**East Midlands Gateway
Phase 2 (EMG2)**

Road Safety Audit 1

SEGRO
East Midlands Gateway 2,
Leicestershire
Stage 1 Road Safety Audit (Entire Scheme)

Document Number	EMG2-BWB-GEN-RSA-RP-TR-0001_RSA1
BWB Reference	220500
Prepared By:	BWB Consulting Ltd
On Behalf Of:	Leicestershire County Council/National Highways

APPENDIX 28: Directional Signage Strategy

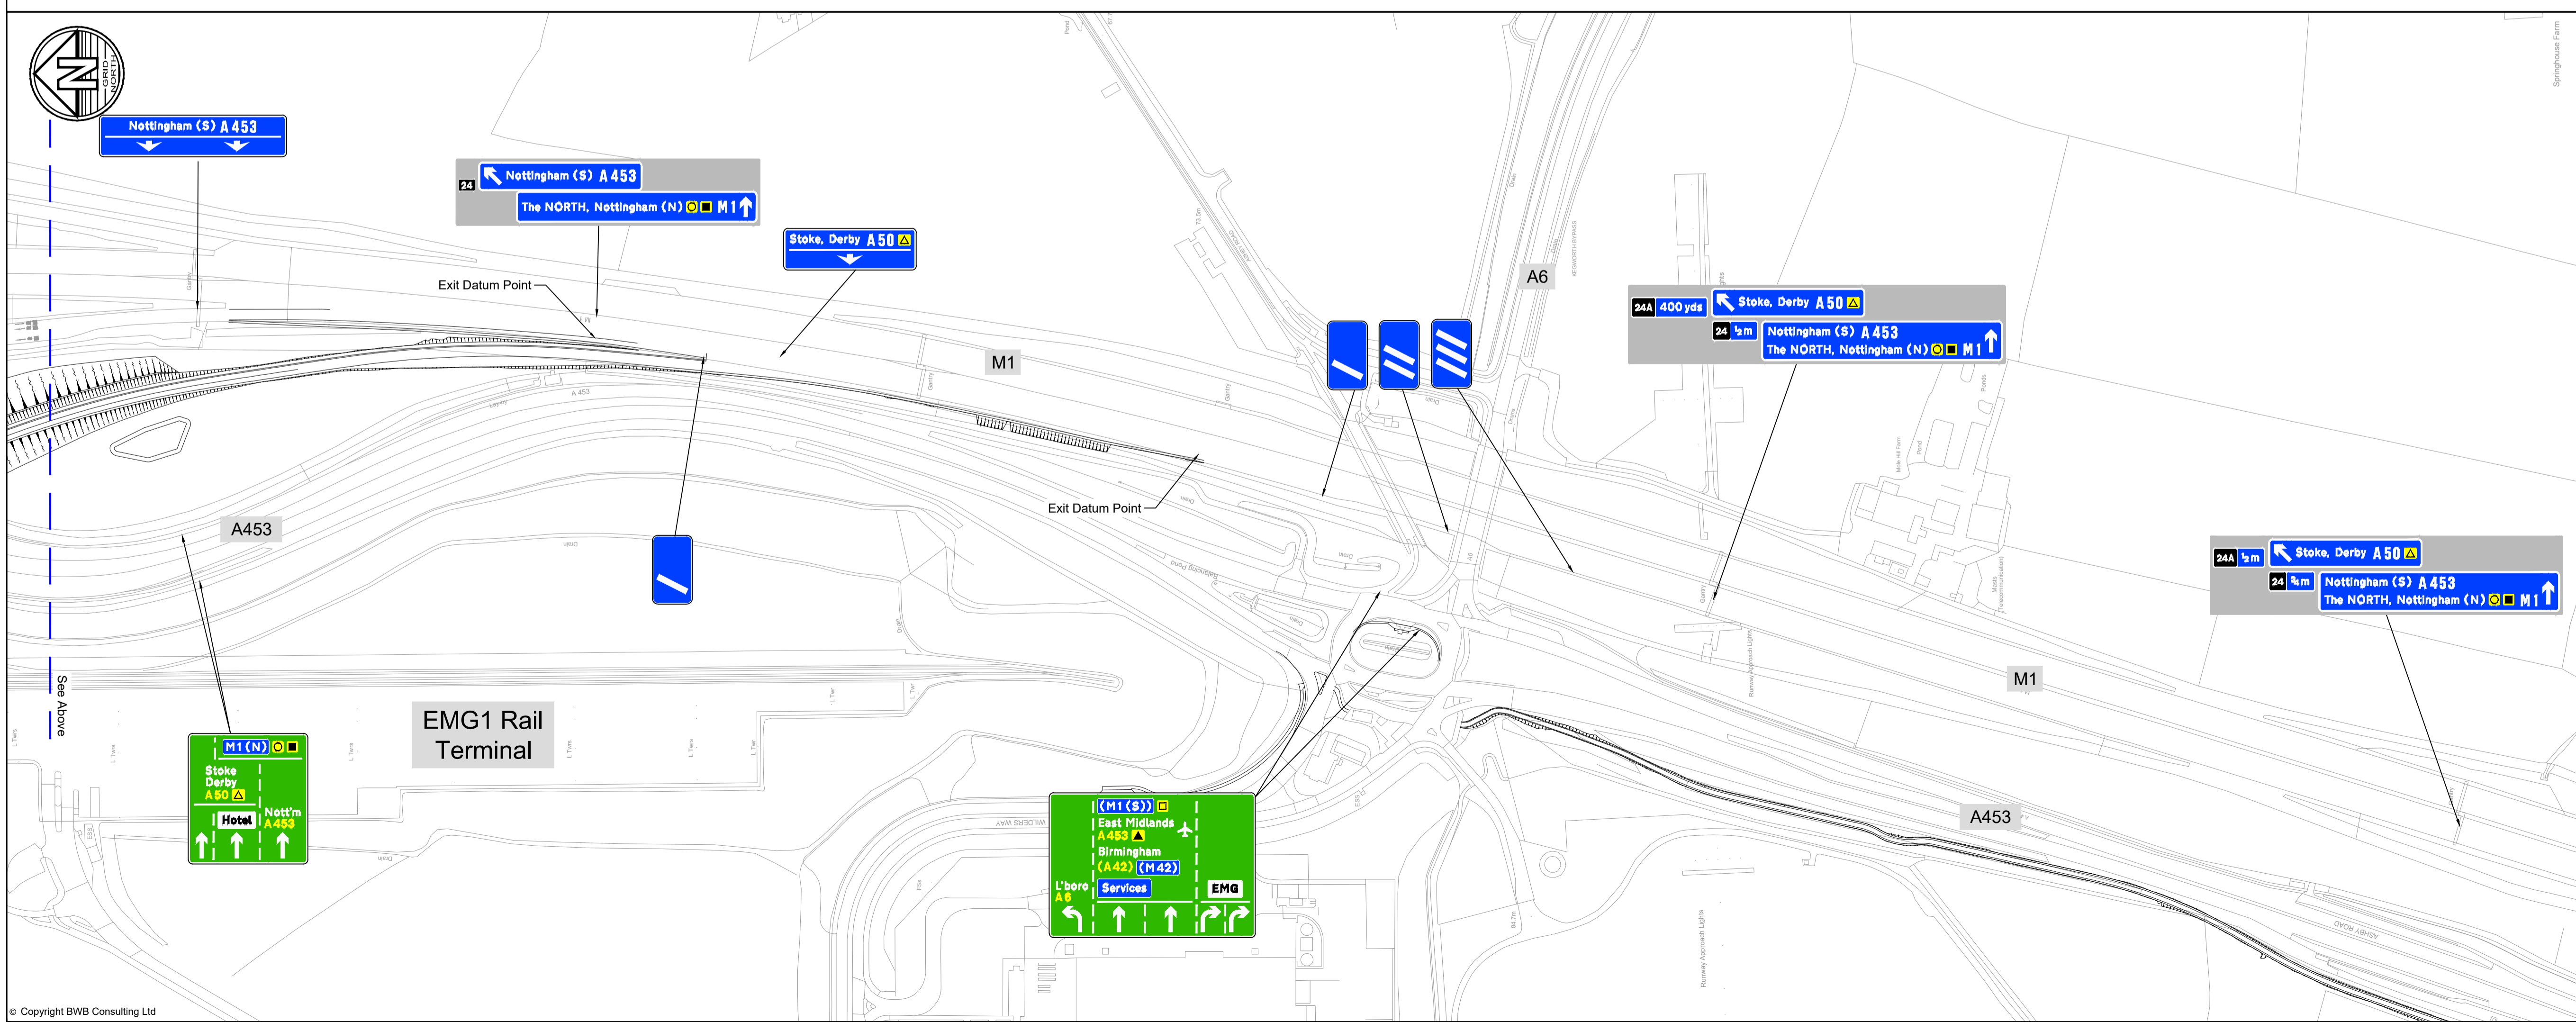
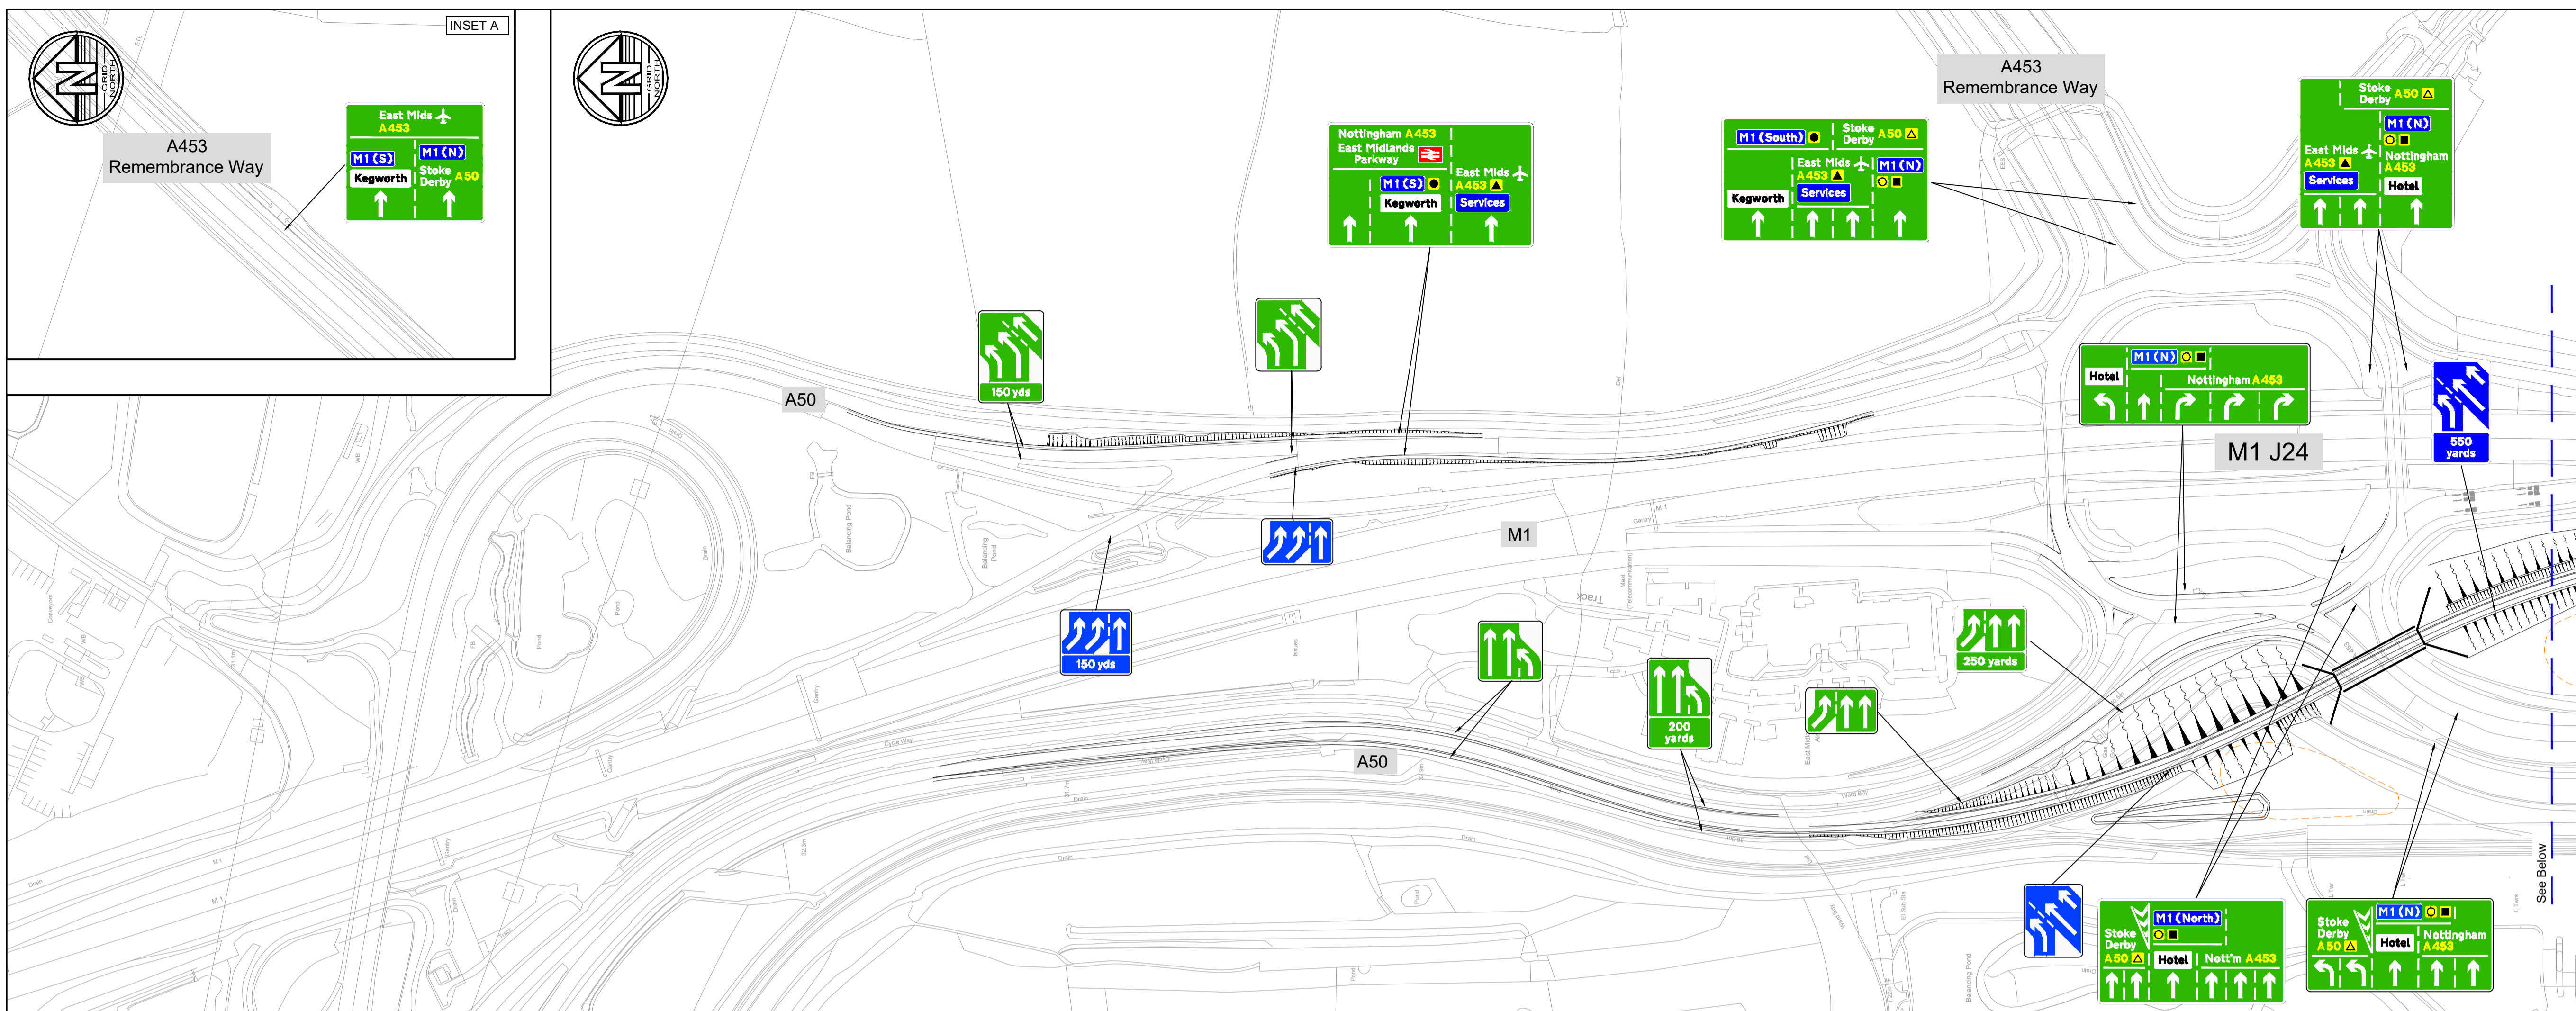
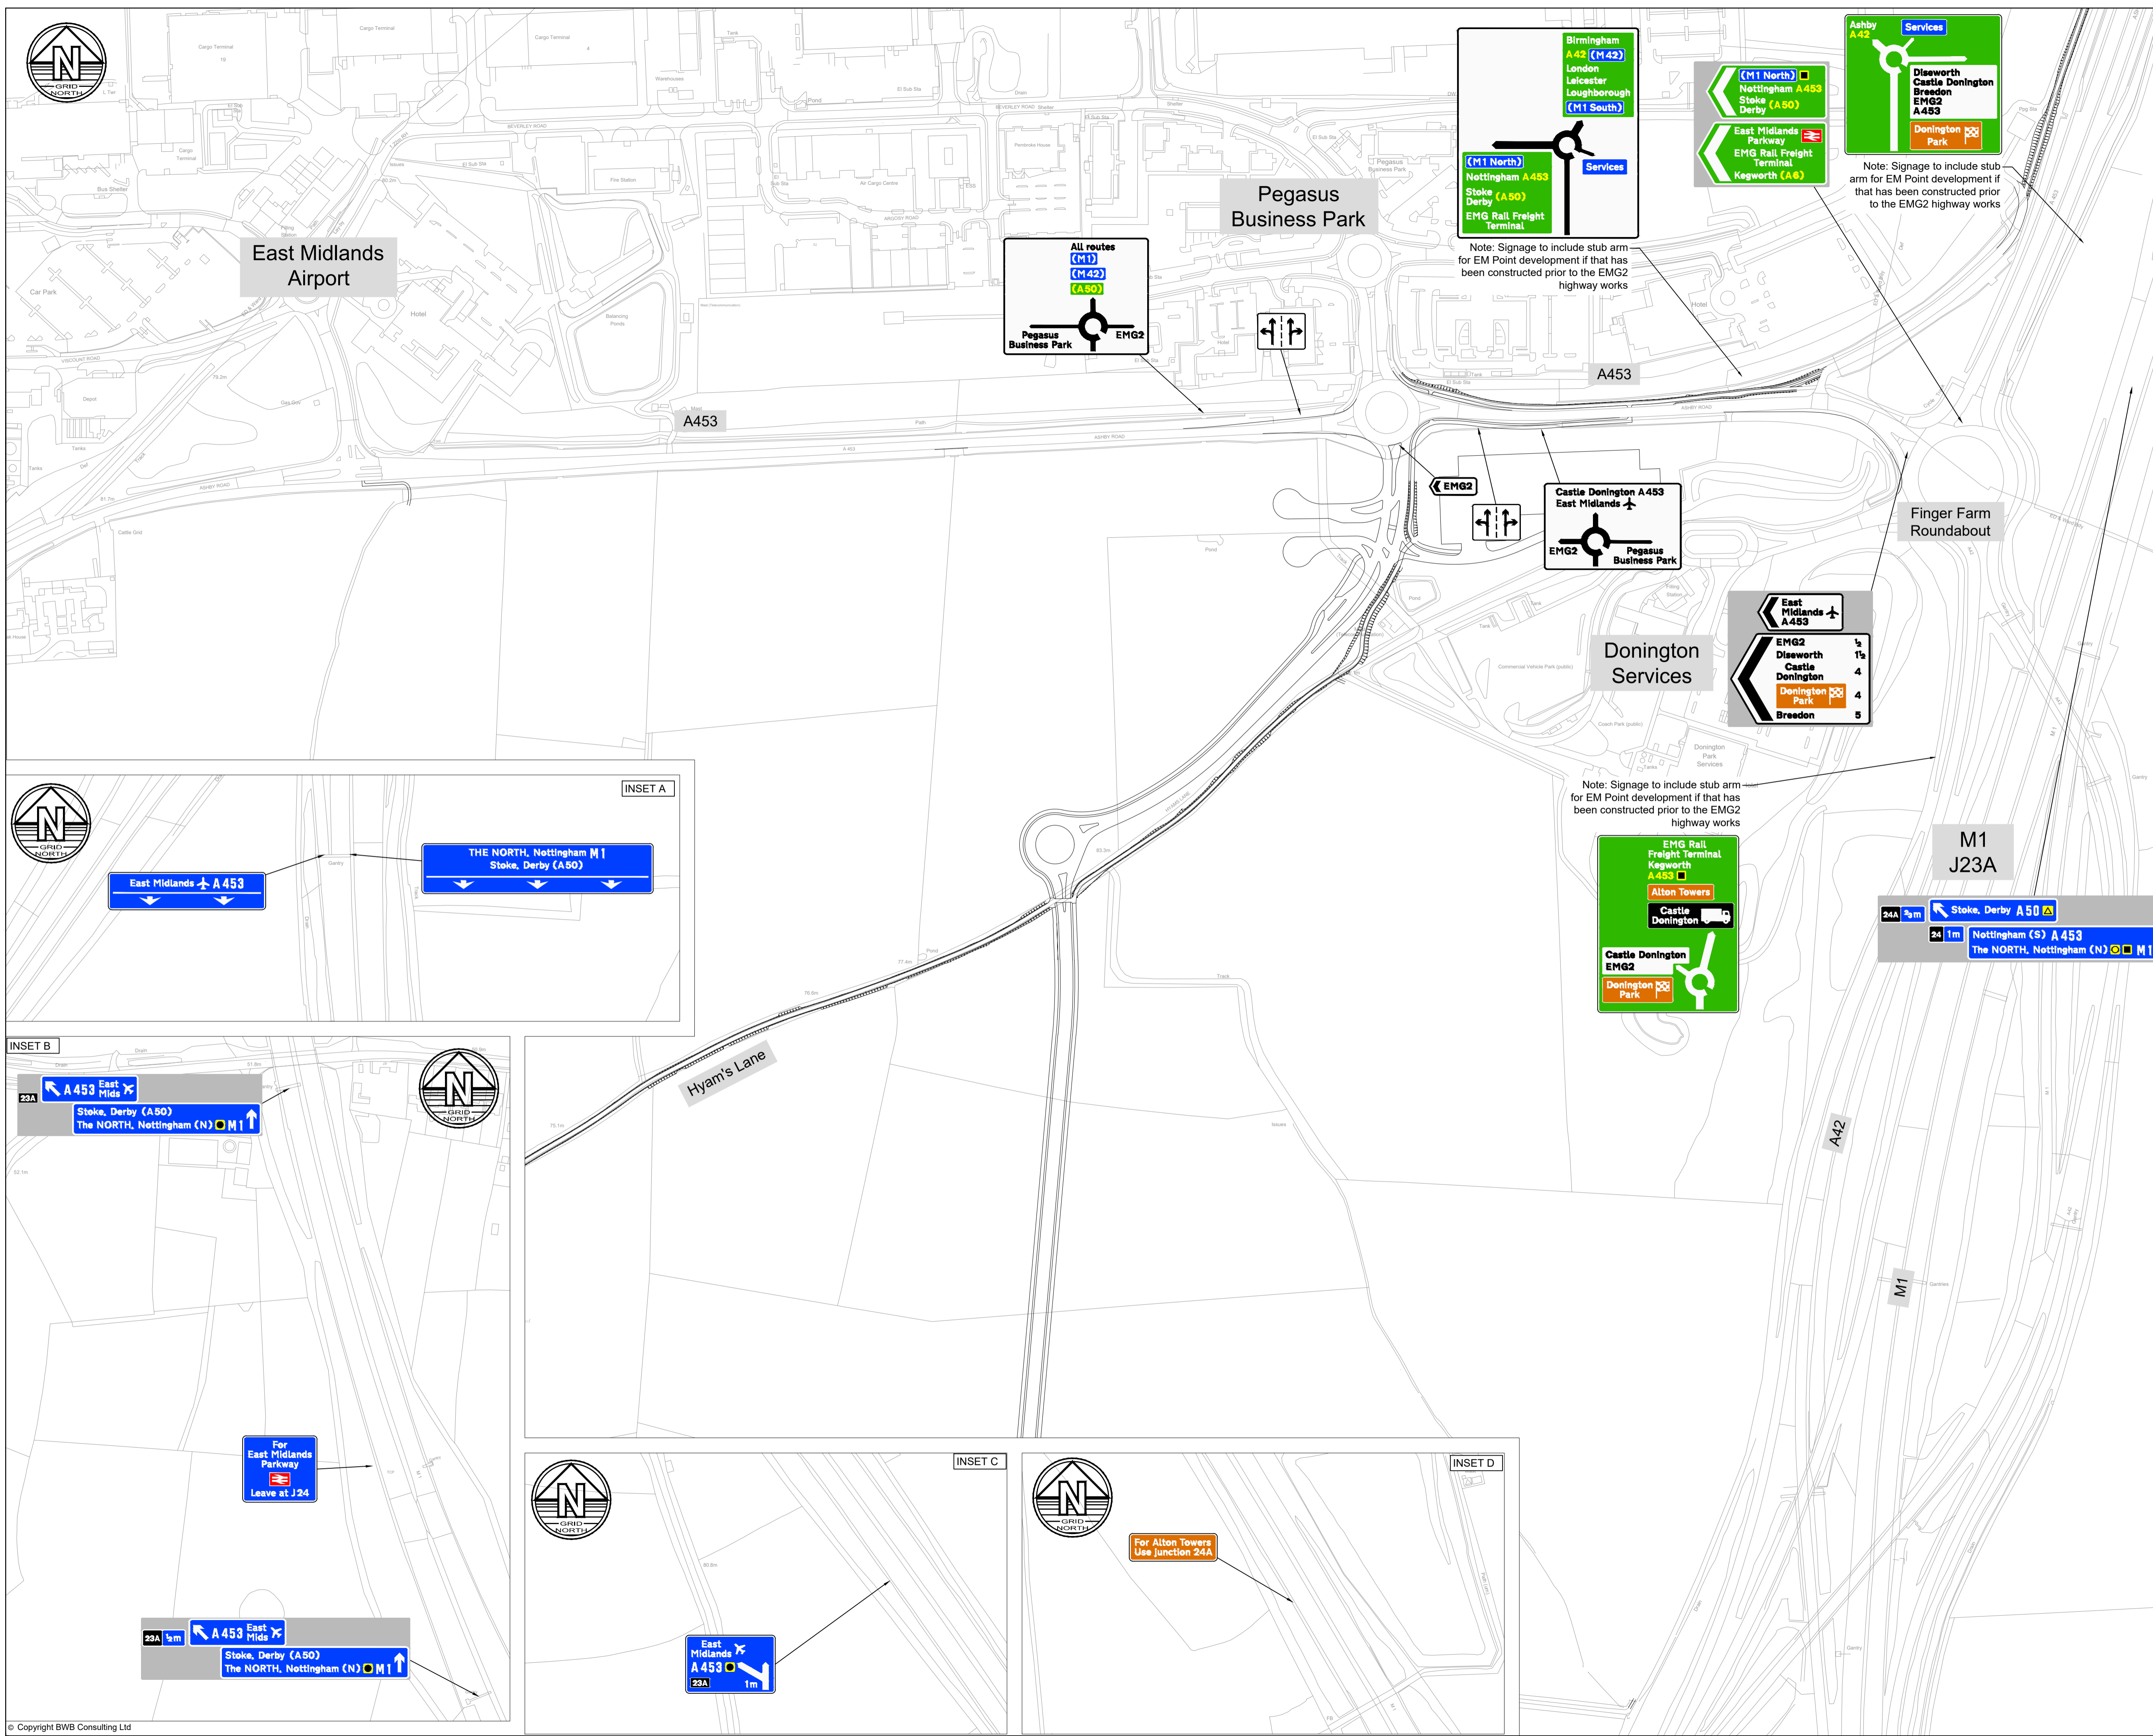
As a result of the amendments at Junction 24, there are a number of changes to the road markings to update the lane destination markings on the approaches to the

junction on the M1 northbound off slip, the A453 approach from the airport and the southern and western side of the circulatory carriageway. However, some of these markings are not consistent with each other and could lead to drivers getting confused and braking sharply or changing lanes at the last minute resulting in shunt or side swipe collisions.

The lane destination markings throughout the junction and on the approach arms should be reviewed to ensure that they are all correct and guide drivers properly through the junction and mirror information provided on upright signing.
